AB/32/13/WMA

Application for a non-material amendment following a grant of planning permission.

ERECTION OF GROUND FLOOR EXTENSION TO THE SOUTH ELEVATION.
EXTEND OUTBUILDINGS BY 1.5M TO SOUTH BOUNDARY TO CREATE
STUDIO/WORKSHOP WITH PITCHED ROOF TO MATCH EXISTING

AB/134/12

SL/06/002

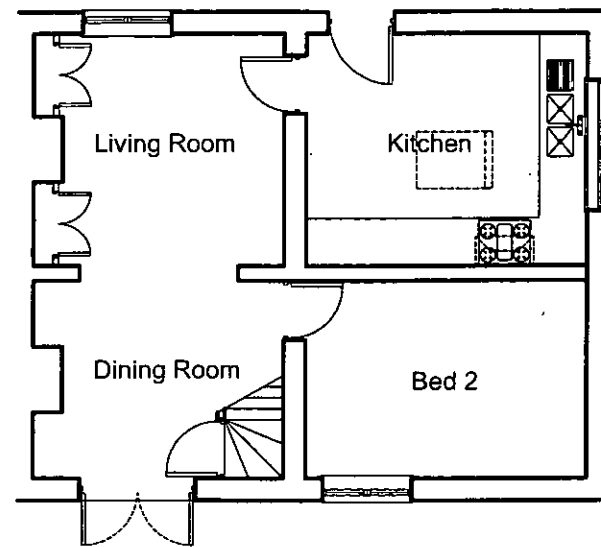
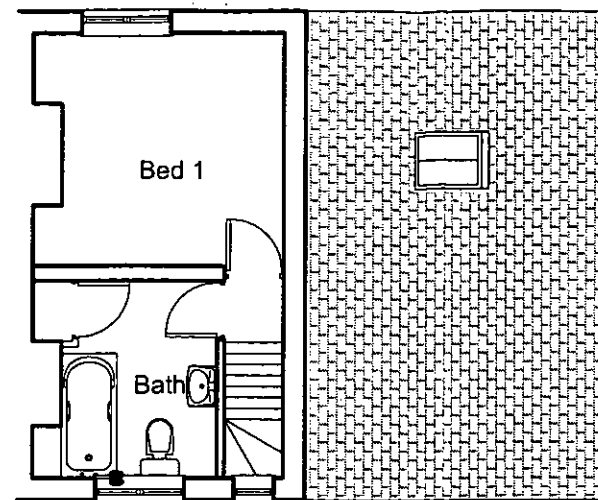
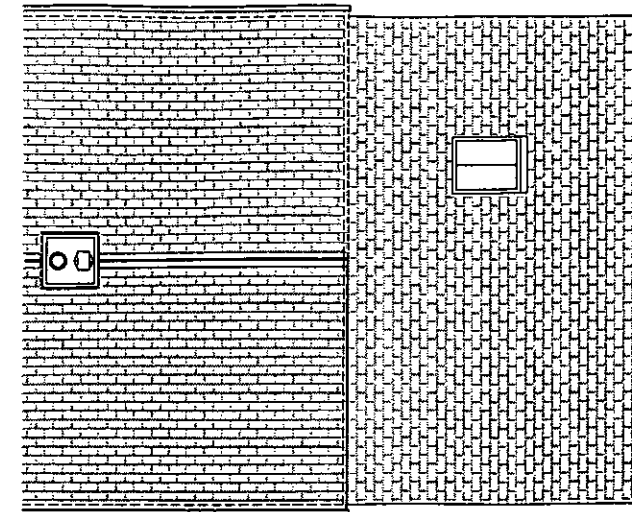
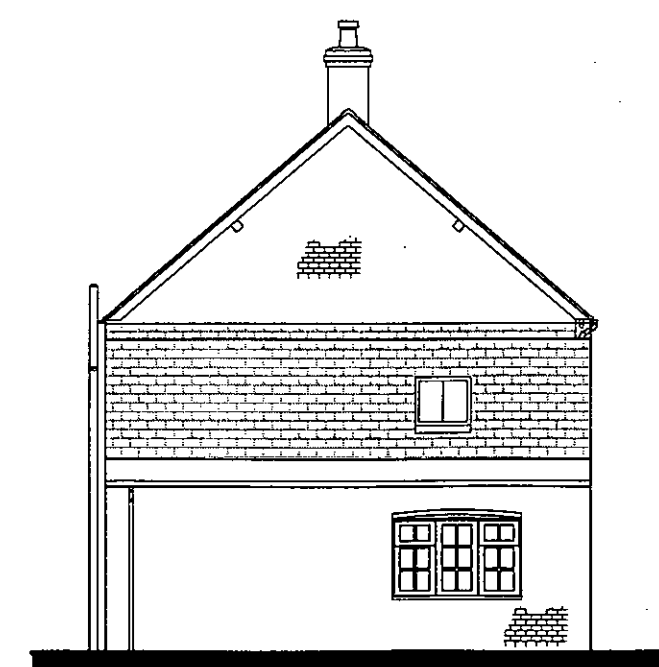
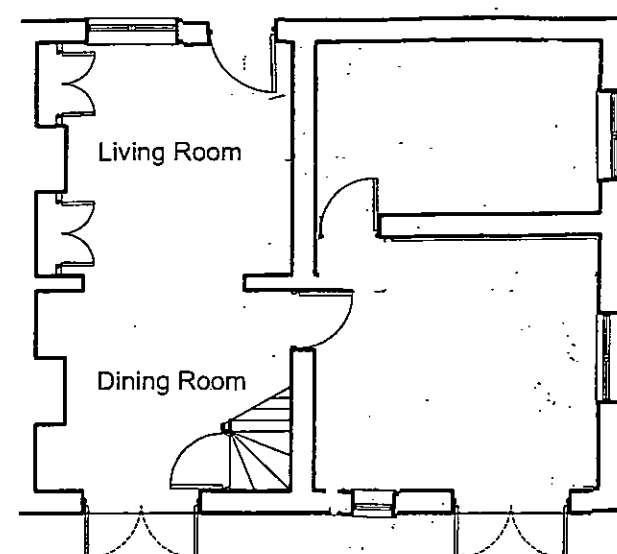
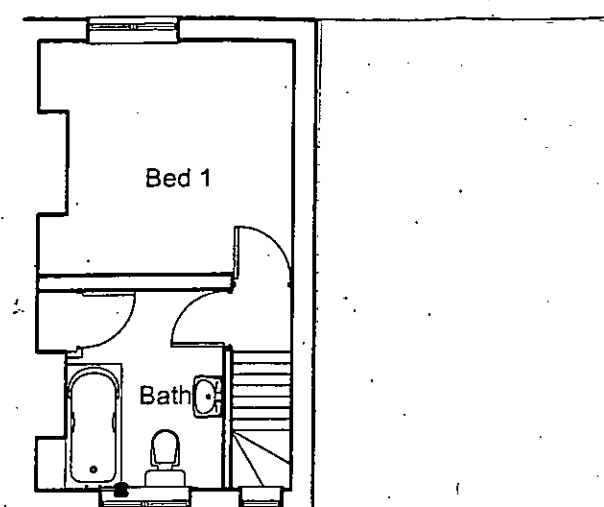
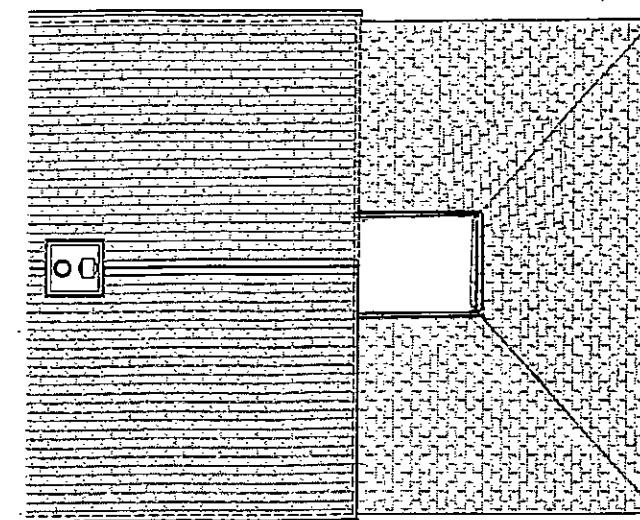
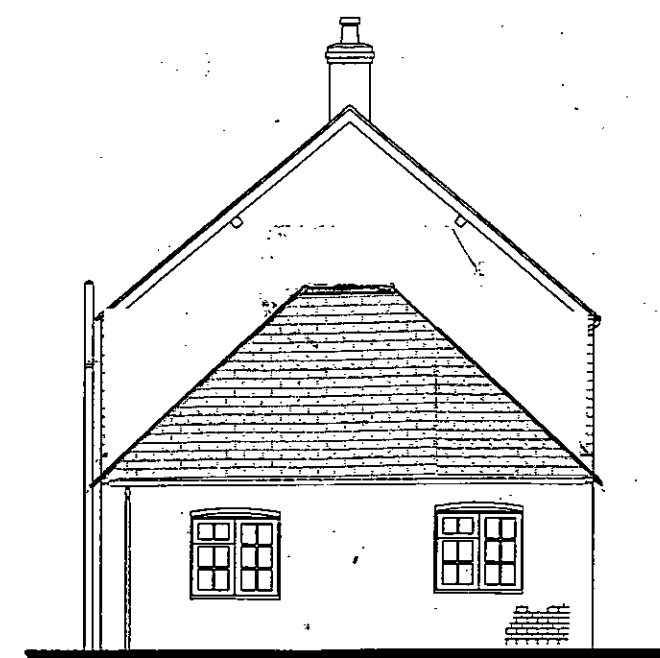
- 1) TO RELOCATE FRONT DOOR BY 2M TO THE RIGHT (FACING PROPERTY)
- 2) TO PUT IN A FRENCH DOOR INSTEAD OF WINDOW INTO THE KITCHEN (TOTAL DOOR DIMENSION OF 2.7 X 2.07M)
- 3) PUT IN ADDITIONAL WINDOW INTO THE KITCHEN LOOKING OUT SOUTH & MATCHING SIZE WITH BEDROOM WINDOW (1.2M X 1M).
- 4) TO CHANGE EXTENSION ROOF FROM SINGLE PITCH ROOF TO HIPPED ROOF

- 1) TO UTILISE ORIGINAL FRONT DOOR OPENING WHICH HAD BEEN BRICKED OVER SOME YEARS AGO
- 2) TO GAIN ACCESS TO THE GARDEN FROM THE KITCHEN.
- 3) TO ALLOW EXTRA LIGHT INTO THE KITCHEN.
- 4) FORMER ROOFLINE LOWER ANGLE THAN ANTICIPATED.

SL/06/002 REVISION E
